DOC16/630090
SSD 6236 Amended EIS Exhibition

Exhibition of Amended EIS - Eastern Creek Energy from Waste Facility (SSD 6236)

ATTACHMENT 1 - Office of Environment and Heritage (OEH) comment on the Amended Environmental Impact Statement for the proposed Energy from Waste Facility at Honeycomb Drive, Eastern Creek (SSD 6236)

Figure 6: Aboriginal site areas overlaid with proposed area of impact

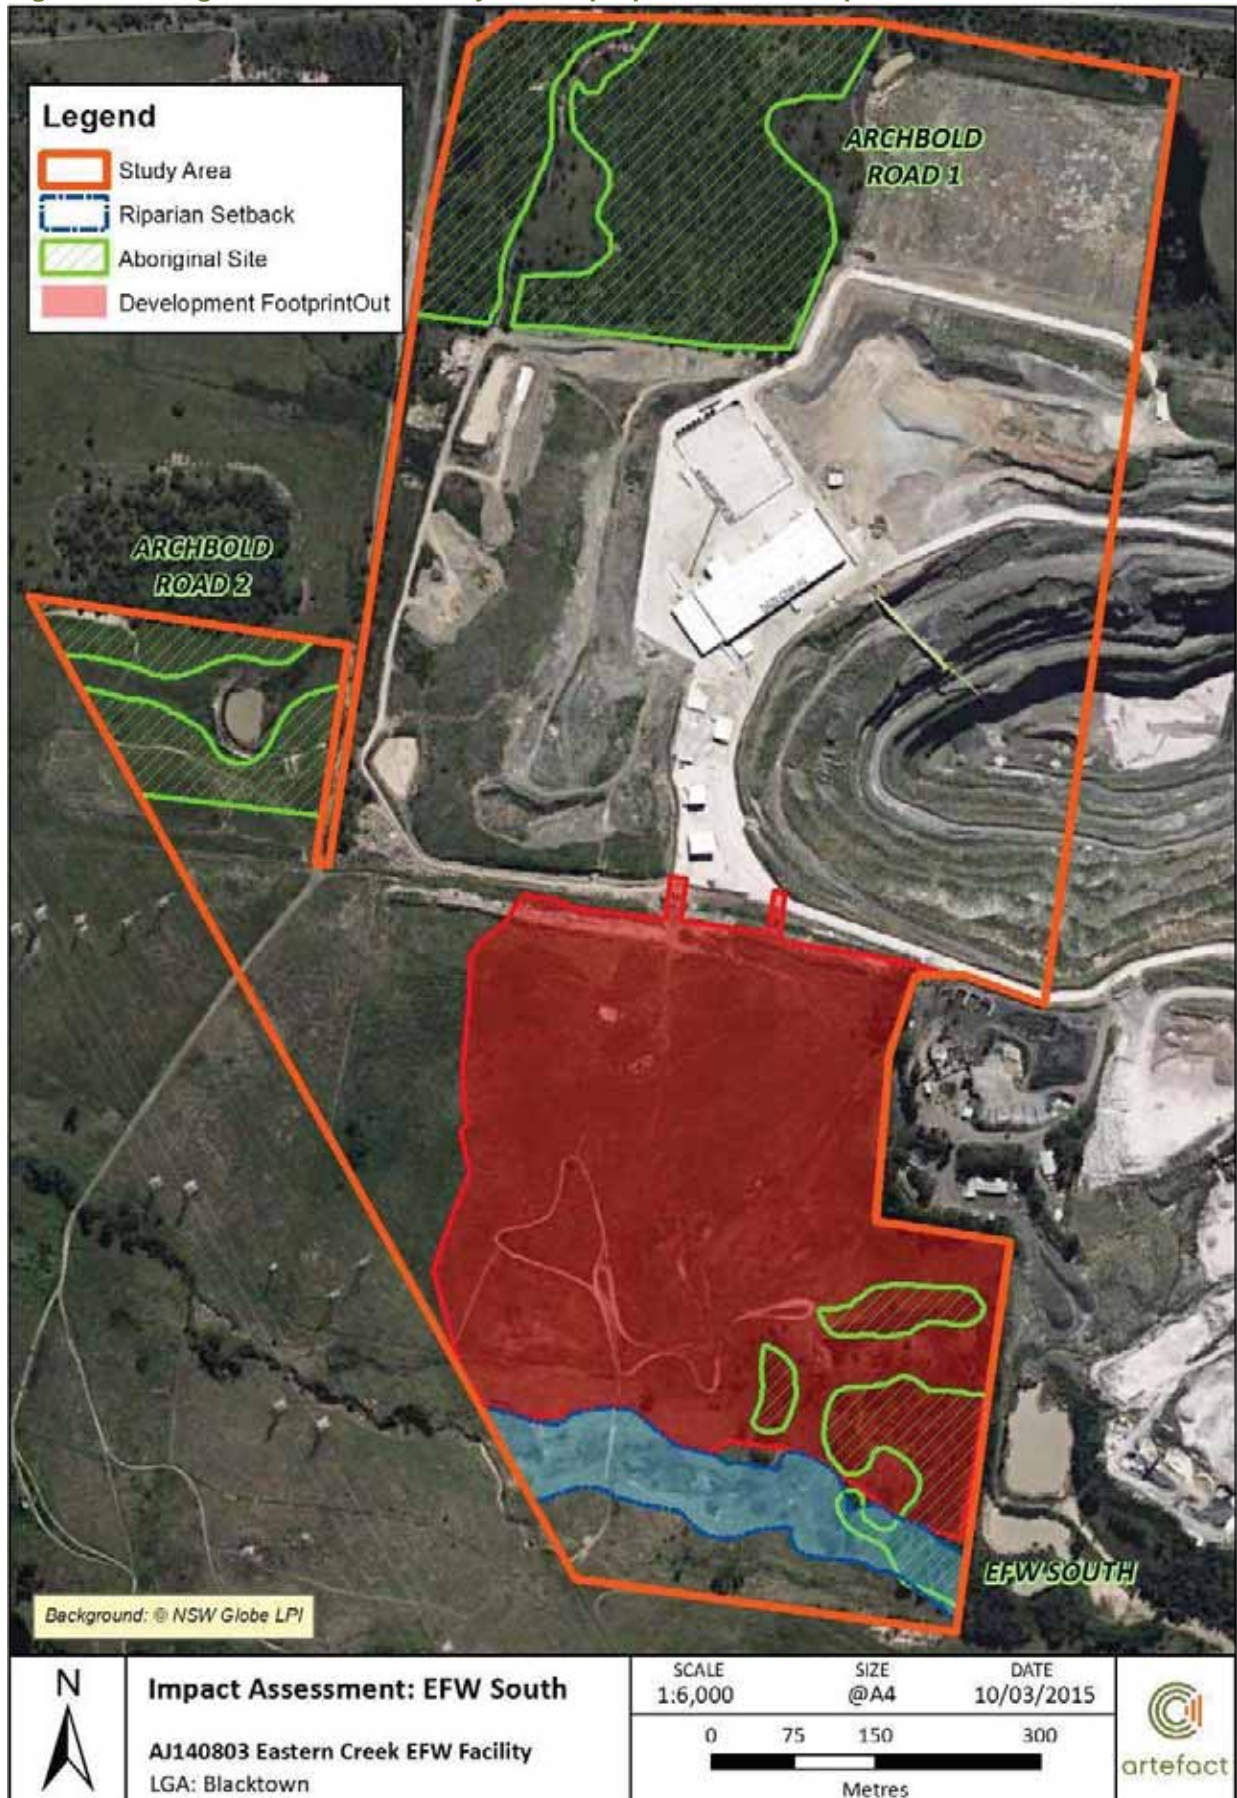
It is not clear in the supporting EIS or Amended ACHAR prepared by Artefact Heritage what is proposed for the long term conservation of Archbold Road 2 other than avoidance during the proposed construction program for this State Significant Development. If this site is not specifically protected through an additional conservation zoning then there is no conservation outcome and the ACHAR and EIS should make this clear. OEH requests that the proponent clarify whether additional conservation measures are proposed for Archbold Road 2 and what they may entail, to clarify this matter for both the Aboriginal community involved in this project and DPE/OEH.

In the amended EIS it is stated that the application area has been refined in the amended application and no subdivision or works are proposed to take place over Archbold Road 2. Measures will be put in place to prevent access and damage to the site during site preparation and construction works. However, OEH notes that no measures for the long-term conservation of the site have been proposed. Moreover, OEH is currently aware of a separate proposal from another proponent to develop an asphalt plant over the portion of the site that includes Archbold Road 2 (Part Lot 2 DP 1145808) which is likely to result in impacts to the site. OEH is therefore disappointed that the long-term conservation of Archbold Road 2 does not appear to have been secured.

**Figure 1. Ropes Creek Tributary illustrating existing and amended proposal features**

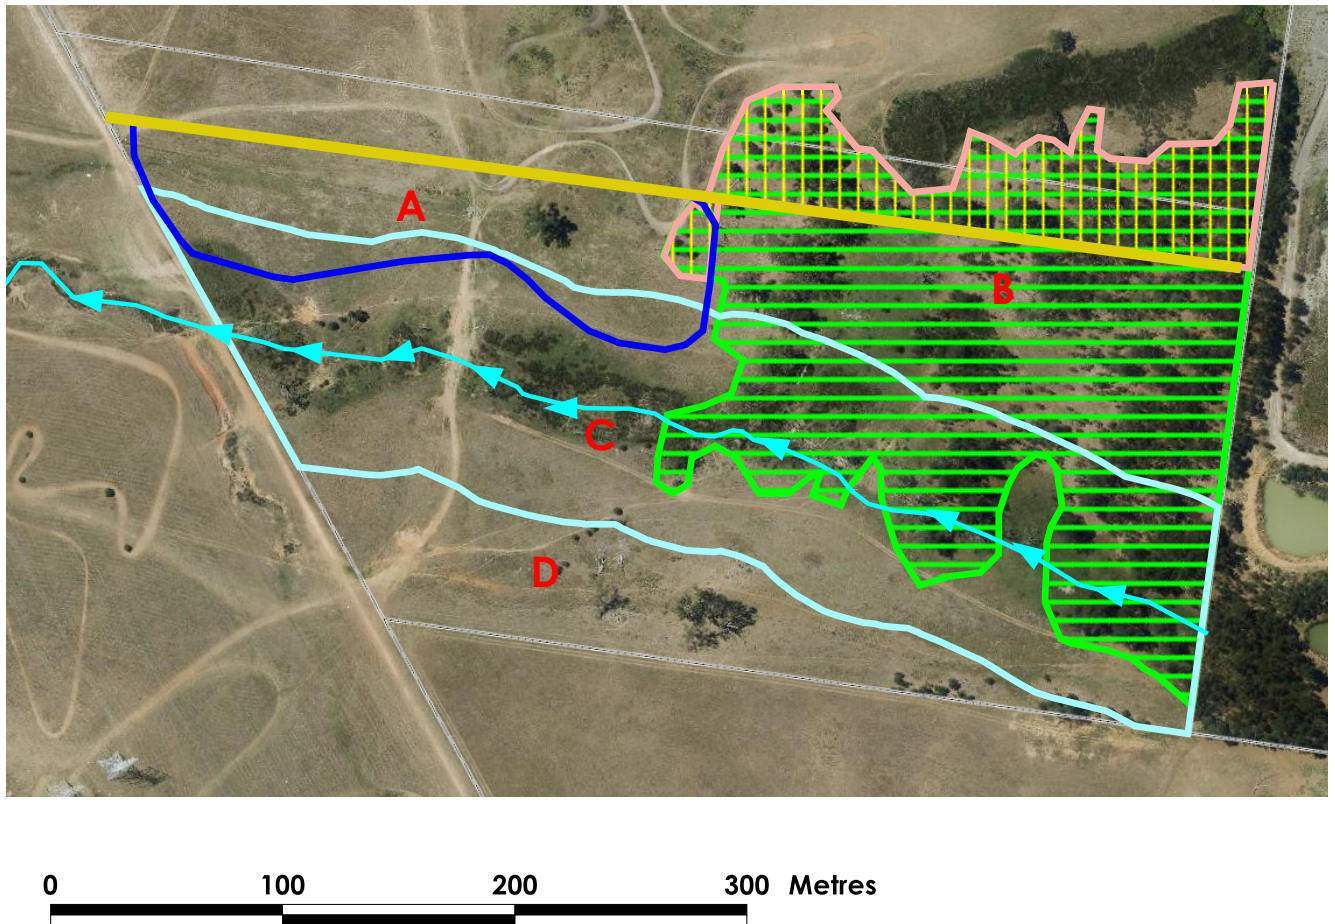
The offsets proposed comprise compensatory planting within the Ropes Creek Tributary riparian corridor to offset the loss of RFEF and Cumberland Plain Woodland (CPW) vegetation. A number of OEH's previous concerns with this proposal remain unresolved:

- OEH previously raised concern that a large proportion of the offset area will be on batters around the building platform and bio-retention basin. The proponent has responded in App HH5 and suggested they will 'sculpt a series of terraces each side of the creek' (page 48). OEH still considers that the likelihood of recreating and maintaining RFEF on batters or terraces is low, given this community naturally occurs on flat, damp or waterlogged floodplains.

- The offset ratios are too low. Adequate offsetting ratios for replanting should be much greater, in the order of 10:1-20:1, given the time required to recreate ecosystems and the risk of failure. Adding to this is the fact that some of land for the offsets is within waterfront land, and includes proposed bio-retention basins within the riparian habitat.

- The areas proposed for regeneration and revegetation have no long term protection, such as appropriate zoning or covenants.

OEH recommends that additional land containing endangered ecological communities be retained within the development footprint and/or offsite offsets provided. App HH5 provides project design justifications for not providing further on site offsetting, and in relation to offsite offsets, it states that

"water supplied, flood prone wetland suitable for an offset in the Sydney metropolitan area cannot be easily procured" (page 41). OEH considers that if options for onsite offsetting are limited or not feasible, then an effort to secure offsite offsets should be made and documented. DPE should be satisfied that all reasonable attempts have been made to procure offsite offsets.
